Comments for Planning Application 21/00167/HHD

Address: 4 Fox Close Bampton Oxfordshire OX18 2NH

Proposal: Demolition of existing conservatory, garage and single storey rear and side structure.
Erection of two storey side and single and two storey rear extensions.

Comment Details

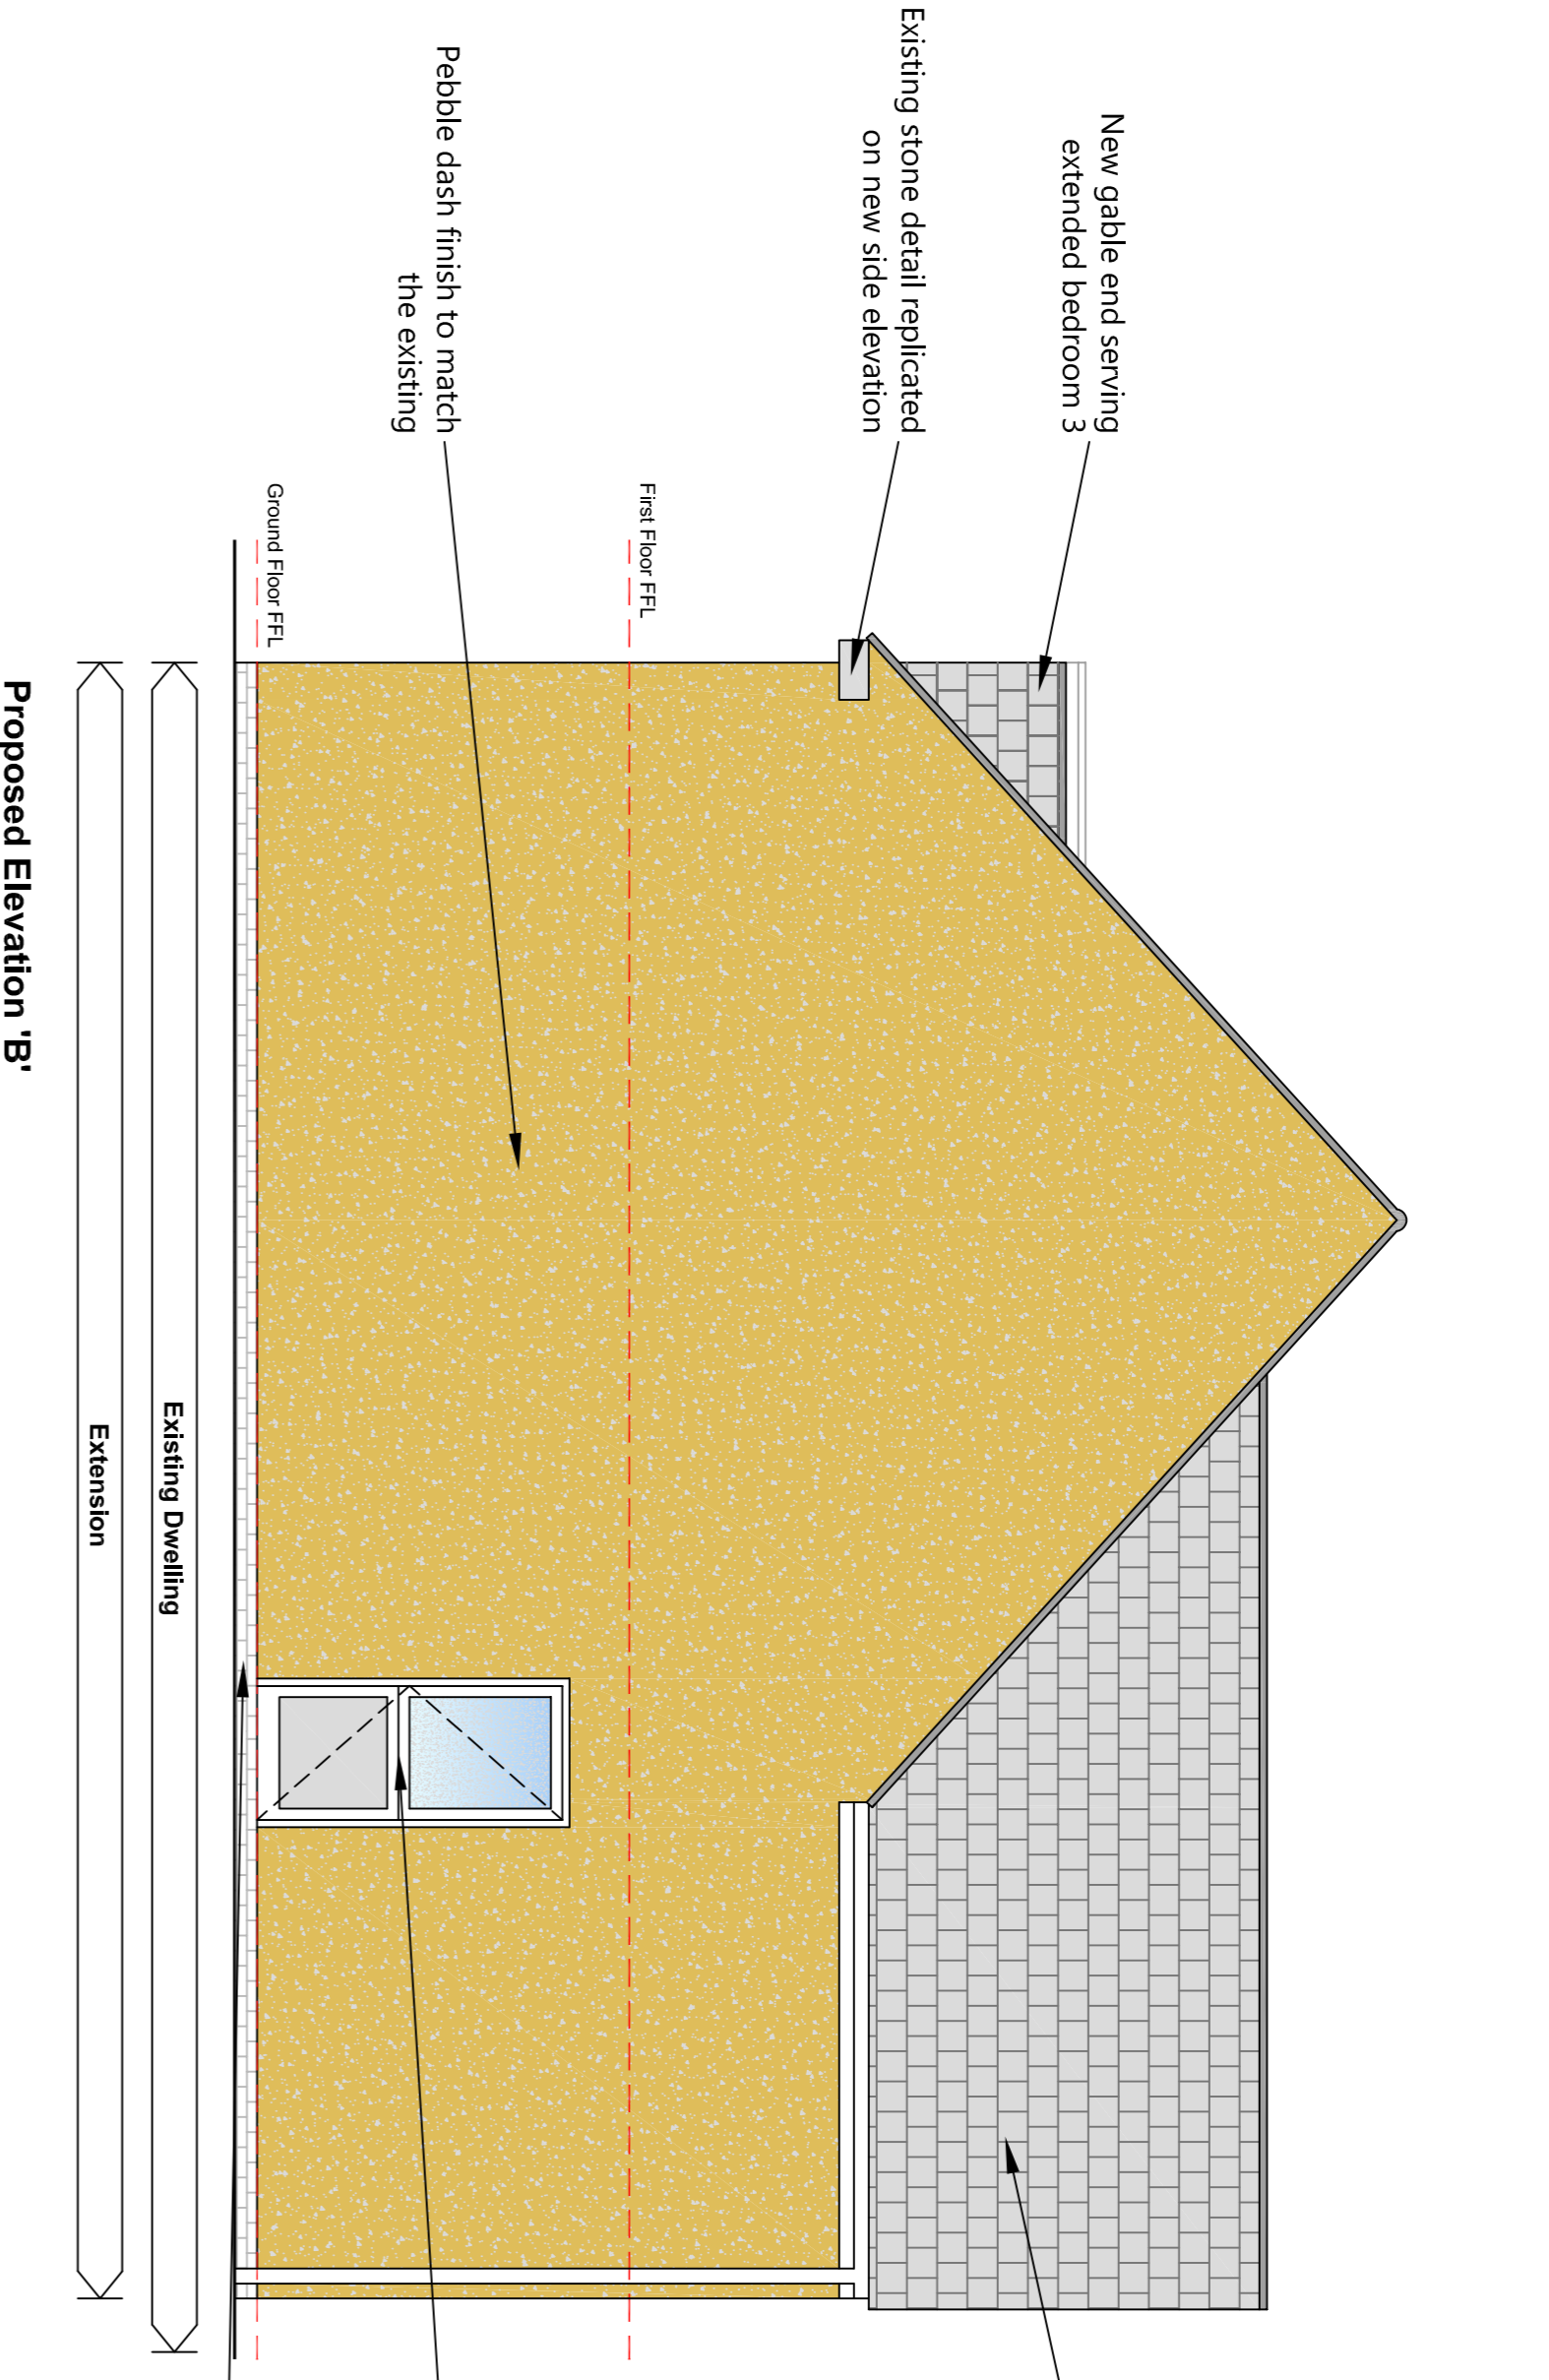
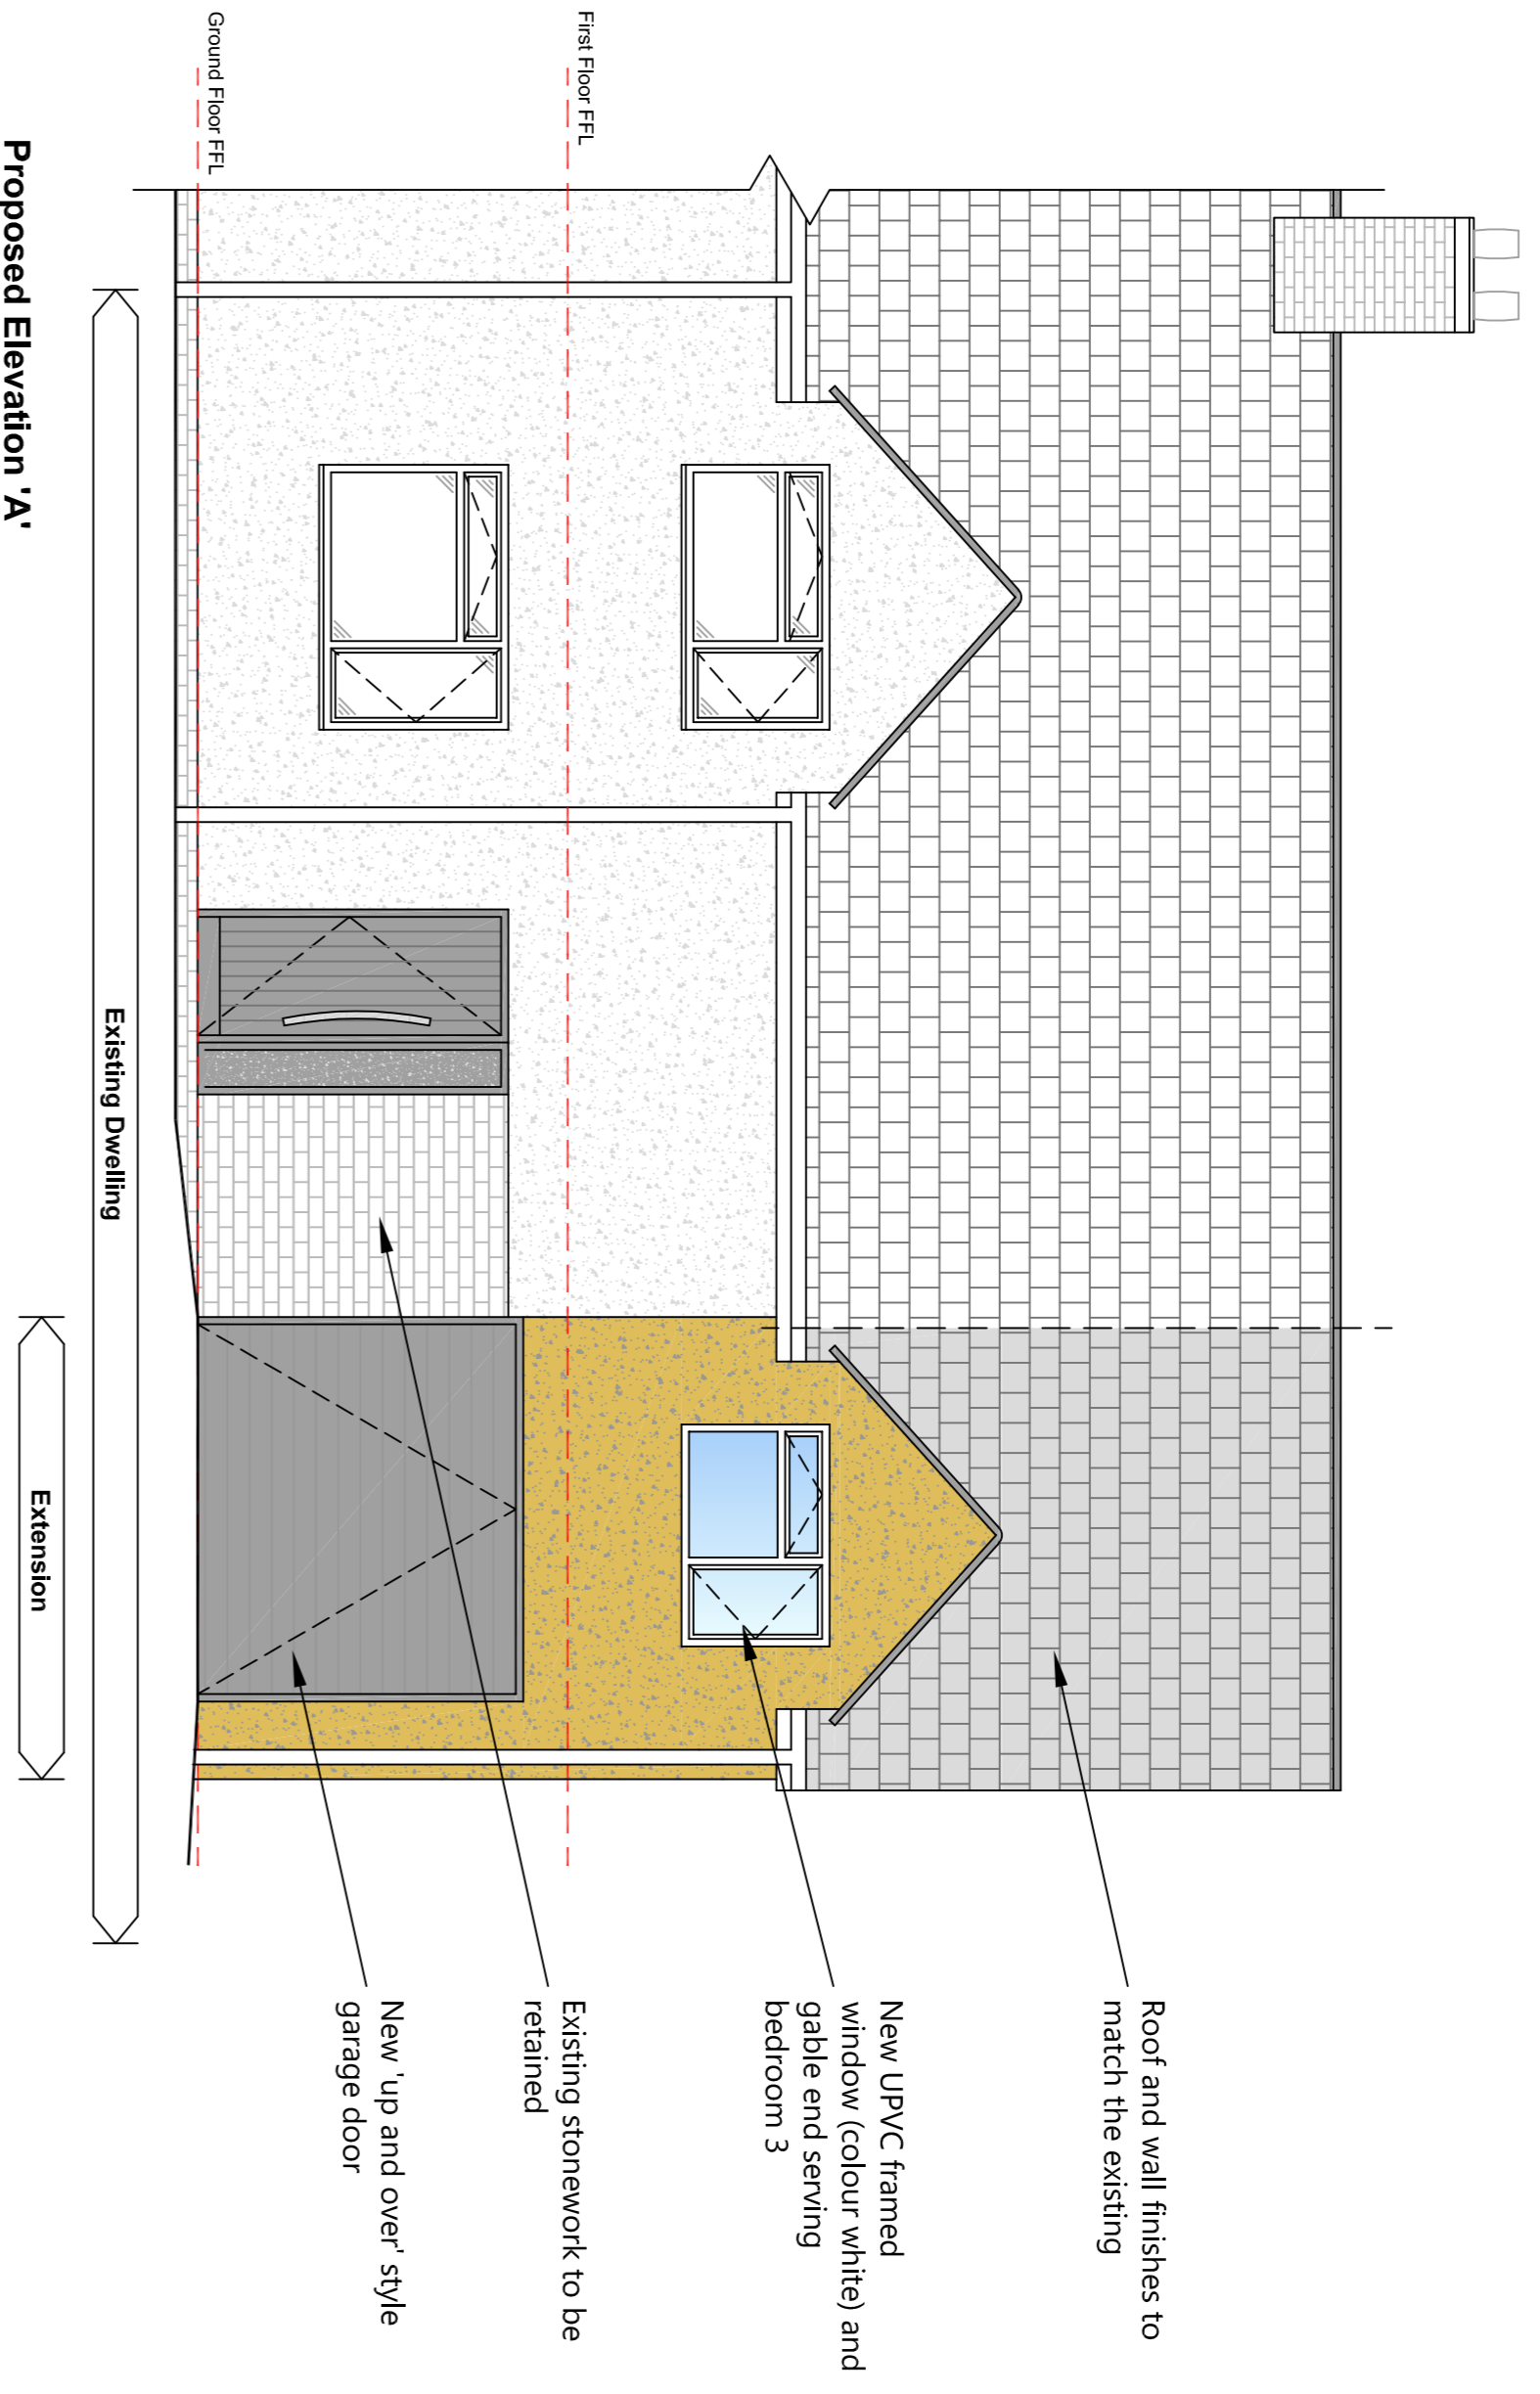
Loss of Privacy: from proposed second storey planned rear bedroom and balcony. The view from this new window and second floor extension will give a view into my sitting room. I note on the proposal that no window was planned to the side to avoid any potential overlooking the neighbouring property, however side bedroom windows already exist in both properties. This same consideration of 'overlooking' has not been given to my property which is to the rear.

As upper bedroom side windows already exist in no 4 and neighbouring house, would it not be more appropriate to keep windows to side of the property as there is already a precedent for this and less risk of 'overlooking' than relocating to the rear of the property?
